## City of Albuquerque Stormwater Construction Site Inspection Report

ESC File No.	M15E036	Project Name:	Sunport Appartments			
NPDES Id. No.	NMR100370	Location:	2601 Mulberry SE			
8/19/2020		Property Owner		Contractor		
Operator		Sunprot Apartments LLC		Snider Construction		
Contact name & title		Zack Snyder		Gary Christiansen		
Contact E-mail		Zsnydernm@gmail.com		gchristensen@snyder-const.com		
Contact Phone #		505-250-8595		c 505-720-8475 o 505-923-3181		
COA Inspector		Doug Hughes		Start/End Time:	7:30/8:40AM	
Construction Phase:		Earthwork				
Type of Inspection:	<input checked="" type="checkbox"/> Regular	<input type="checkbox"/> Storm Event	<input type="checkbox"/> Post Storm Event >0.25"	<input type="checkbox"/> 311/Complaint	<input type="checkbox"/> Follow Up	
Weather at time of inspection?			Clear	Temperature: ~	84	
Estimated date of last storm 0.25" or greater

FIRE 1

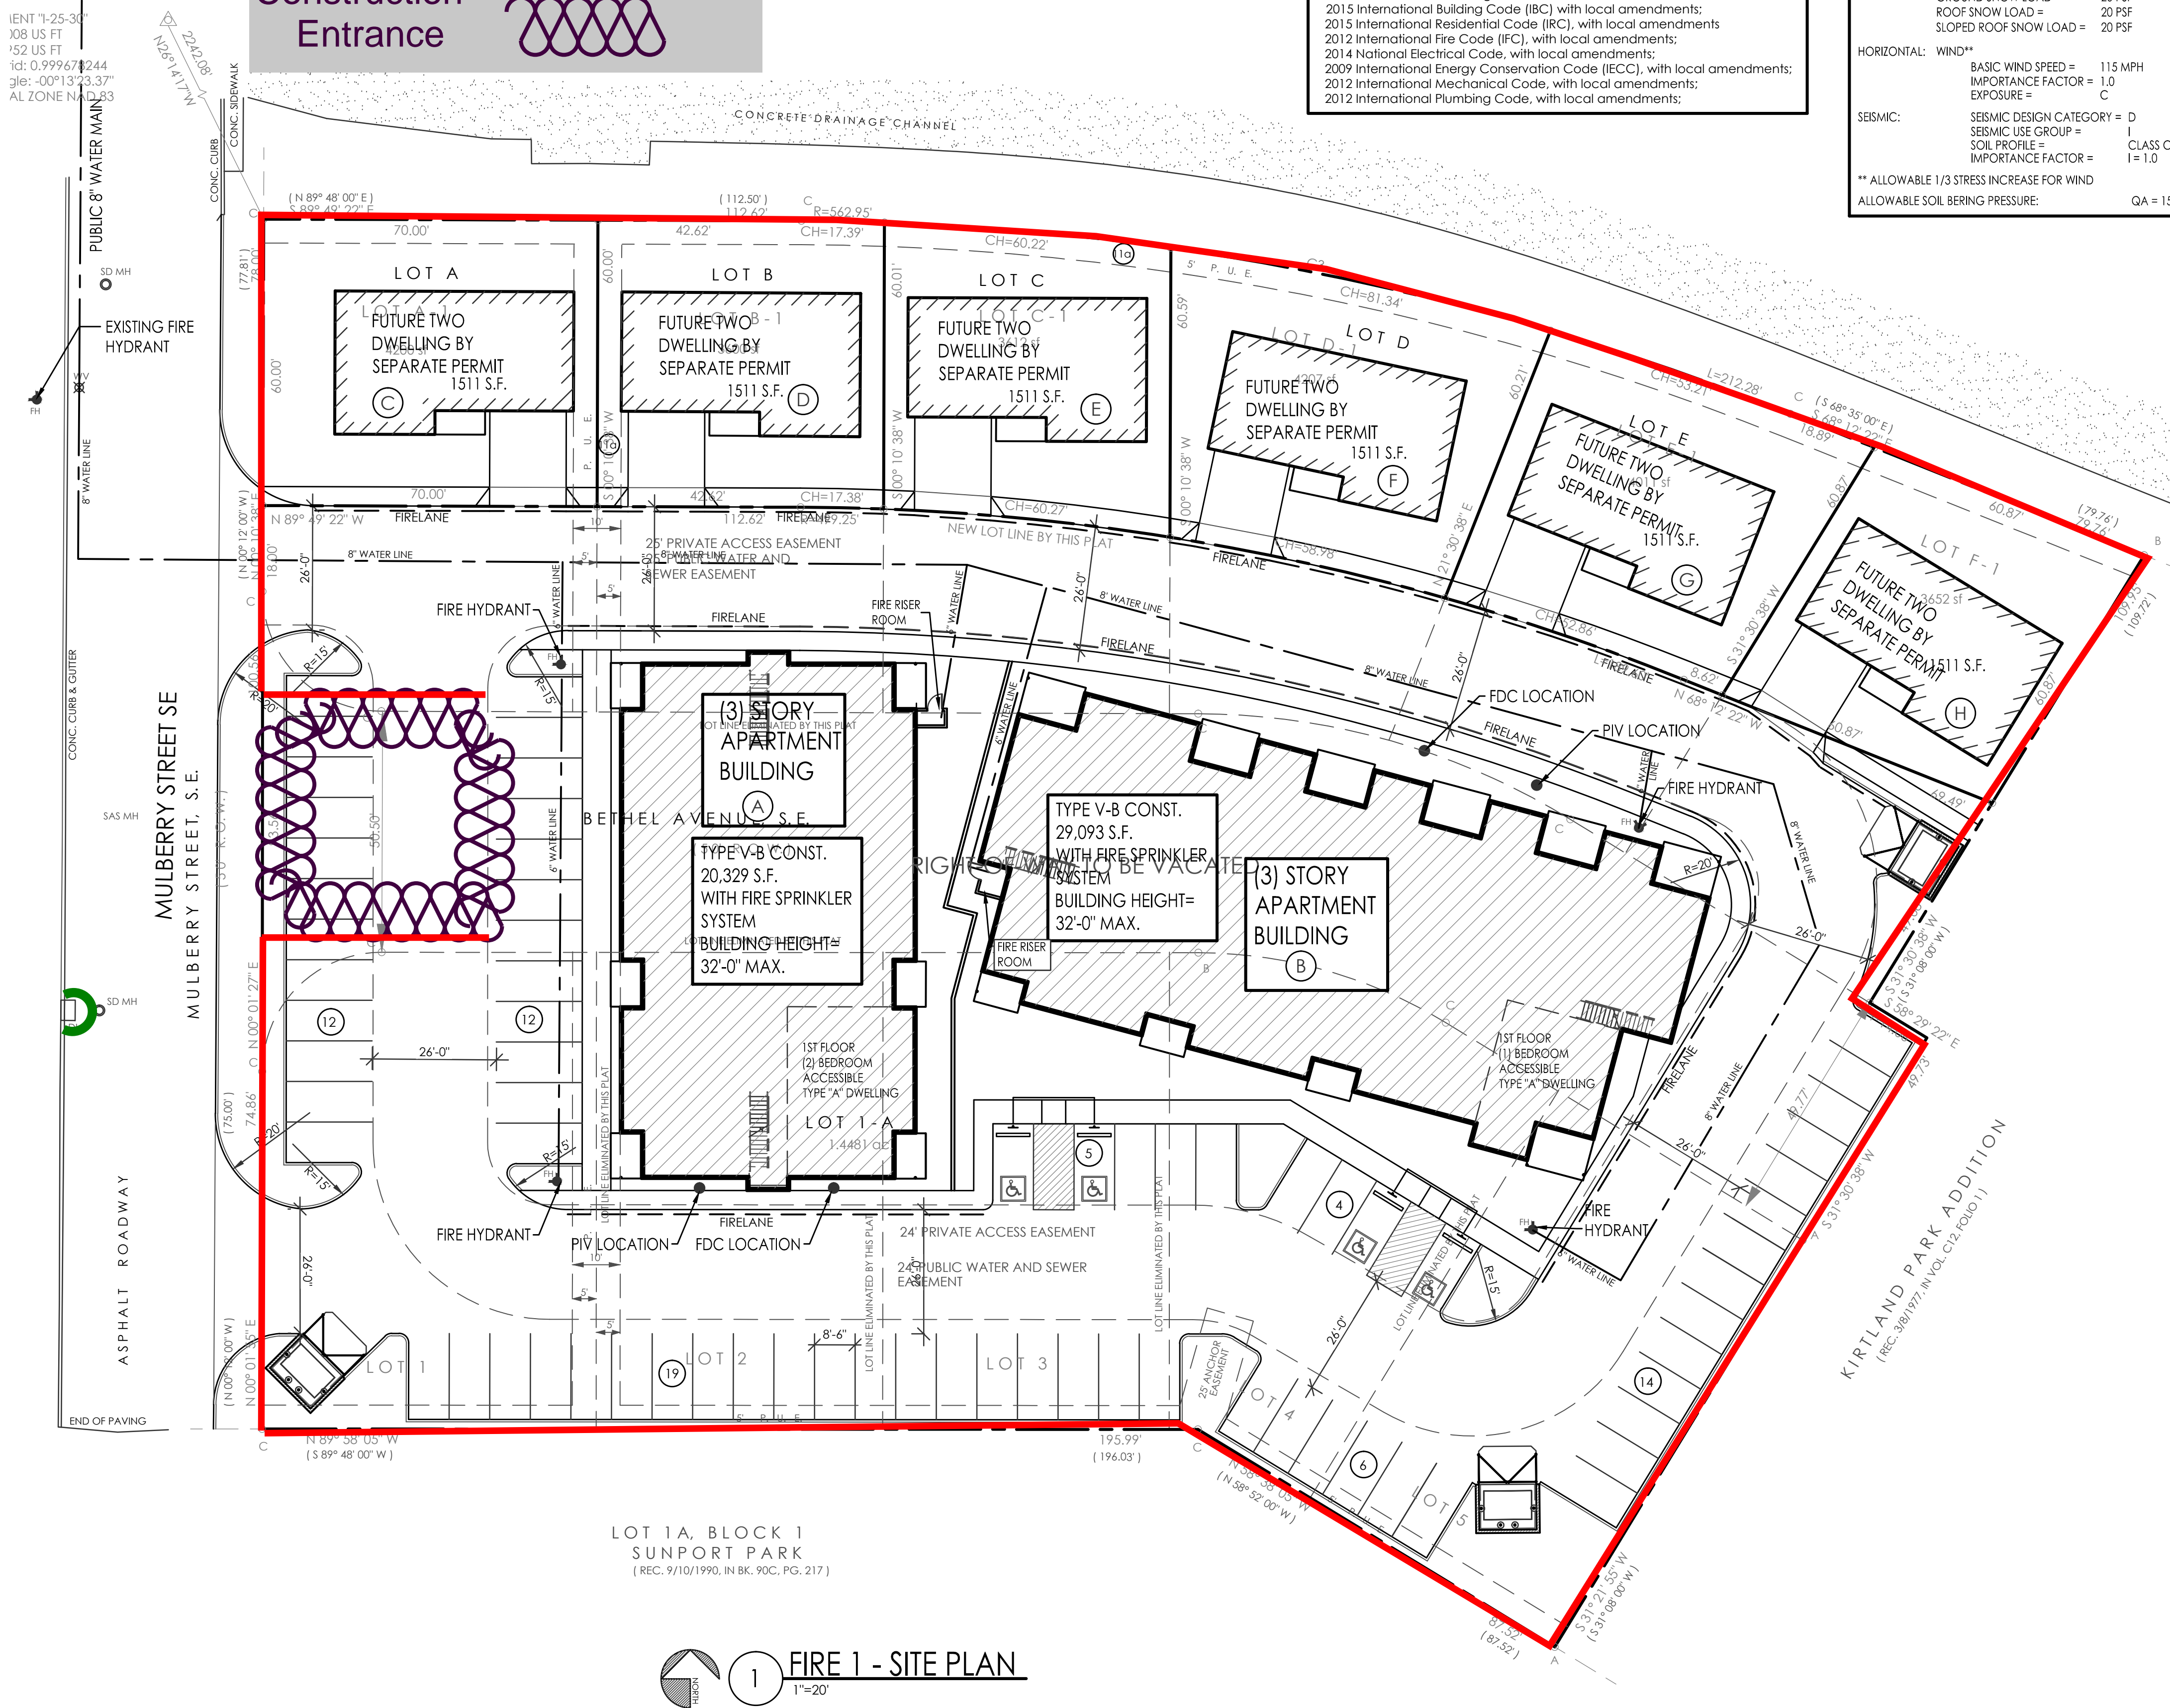
Item Number	Deficiency/ Corrective Action					
1	Track out in street to adjacent lot nw of Site. Remove sediment from ROW same day it occurs.					
2	Construction entrance muddy. Reset and modify entrance to prevent sediment.					
3	Operator signature missing from SWPPP. All operators must sign.					
4	ESC Plan and property owner's NOI must be approved by the City for all lots involved in this site.					
5	Silt fence is not at limits of disturbance along street and not embeded properly.
